Planning Application Ref: A/161/21/DOC

Location: Broadlees, Dappers Lane, Angmering, BN16 4EN

Description of works: Approval of details reserved by condition imposed under A/114/18/PL relating to condition 10-retention of existing trees/bushes/hedges.

- I walked the site on 7th October 2021 and had the following **Tree Protection Plan** to refer to:
 - **Drawing No. B21056-601A** from The Landscape Partnership.

Figure 2 Default specification for protective barrier

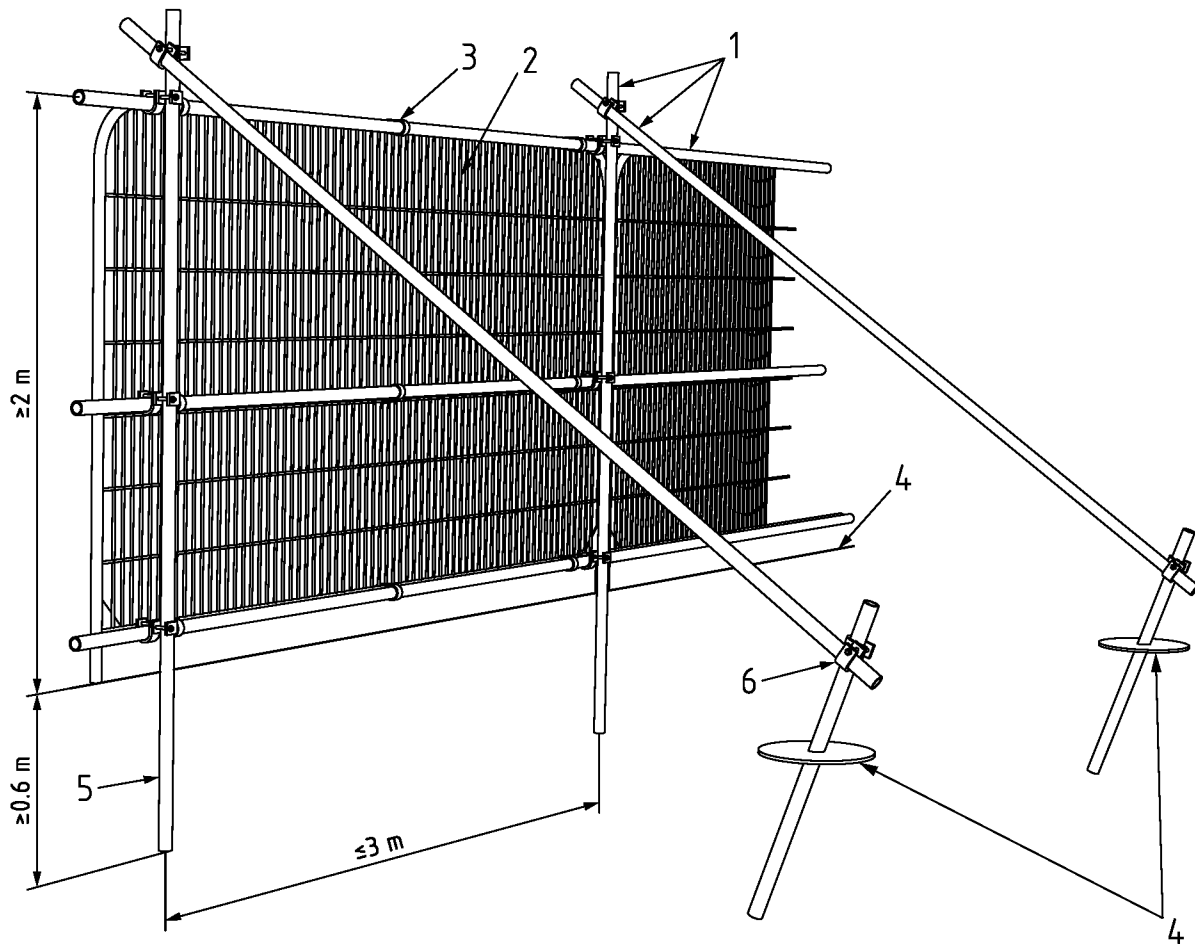
- The plan and supporting report **Tree Protection Proposals** from The Landscape Partnership, July 2021 promote BS5837:2012's default specification for fencing, to form an effective construction exclusion zone (CEZ) around retained trees.
